2025/91370

Far from resolving issues and questions arising from the first submission, the revised submission raises additional questions and issues.

Client	YORKSHIRE COUNTRY PROPERTIES			
Project	GYNN LANE, HONLEY			
Detail	ROAD 1 CULVERT/HEADWALL CONSTRUCTION DETAILS (DRAWING 20F2)			
Dwn PW	Chkd	Date Mar 24	Scale 1:50 1:250	Dwg No. E24/8017/200_02

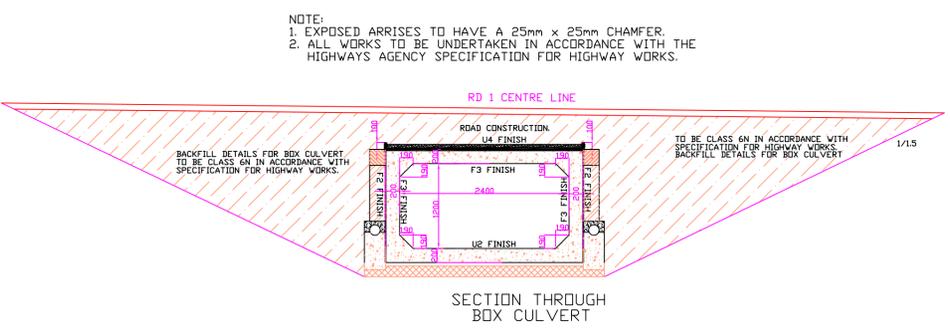
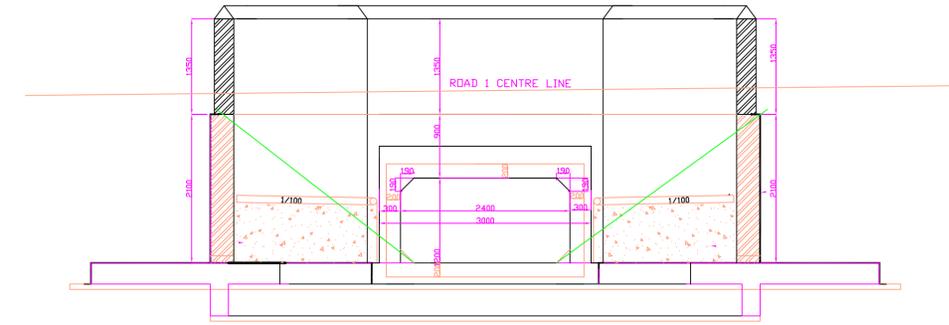
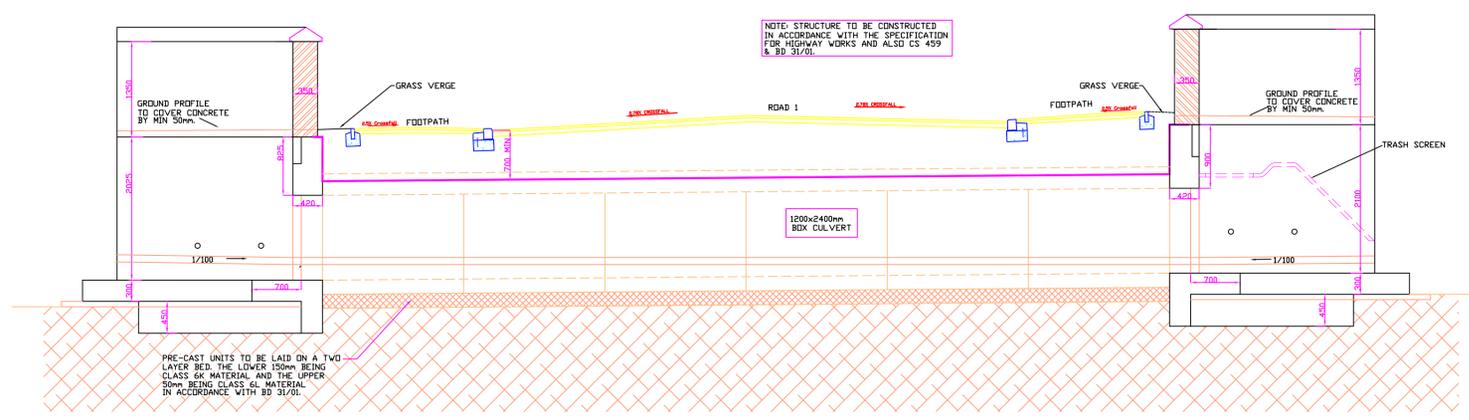
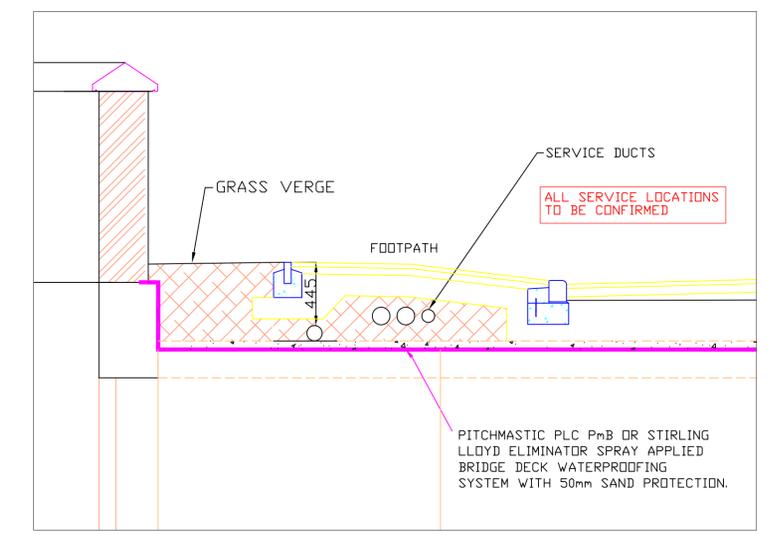
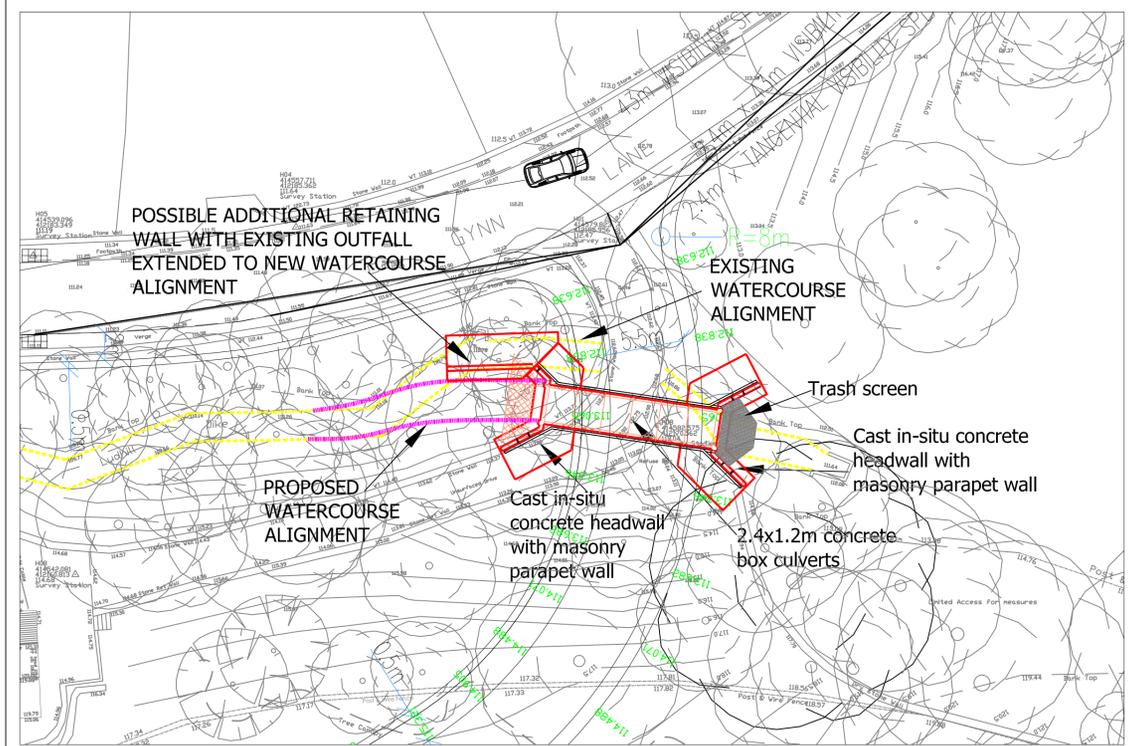
Culverting Ludhill Dike rather than constructing a bridge. Whilst the Environment Agency is not opposed to the development it does defer to the Lead Local Flood Authority for comments in relation to the proposed culverting of the Dike.
